V1_Soils and Geology Report_comments.pdf Markup Summary

SOIL AND GEOLOGY STUDY

**2825/2819 Slocum Road
Lots 1 and 2, Amo Acres, Filing No. 1
El Paso County, Colorado**

FINAL PLAT
AMO ACRES FILING NO. 1

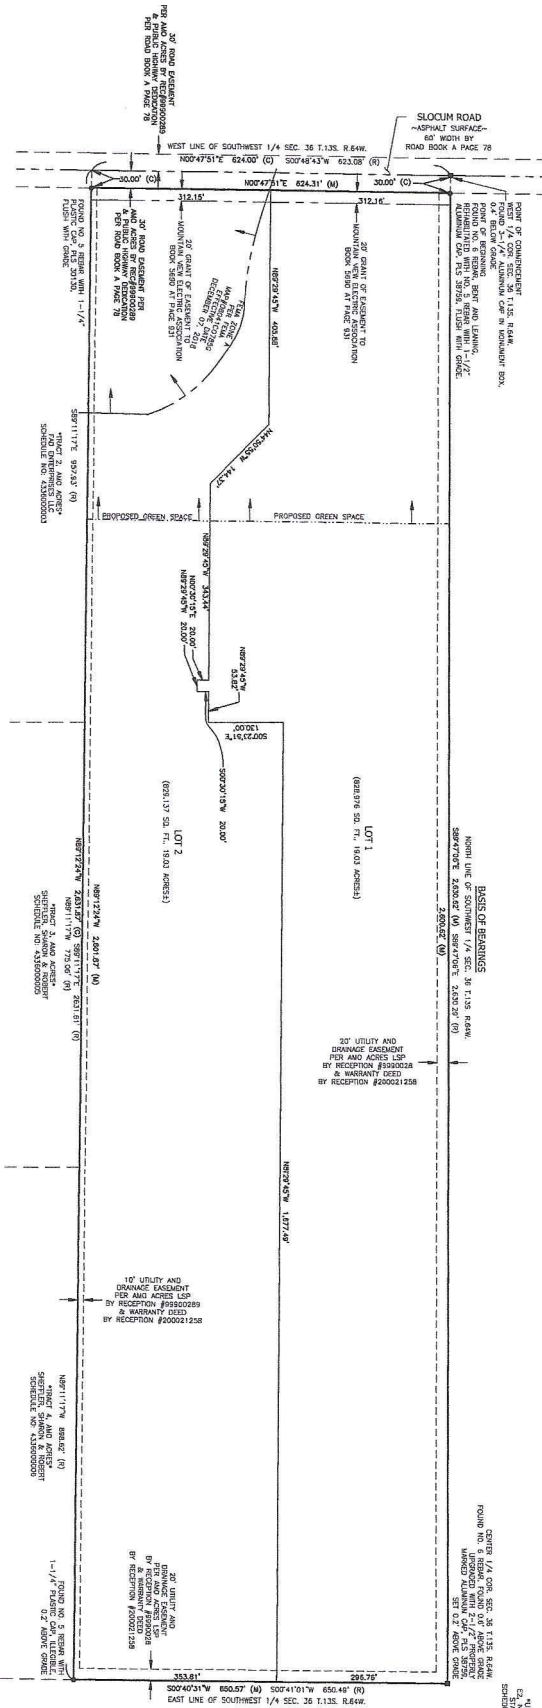
Portion of the site is within the 100 year Floodplain Zone A, the BFE's are required to be shown on the Final Plat (see related comment on the plat).
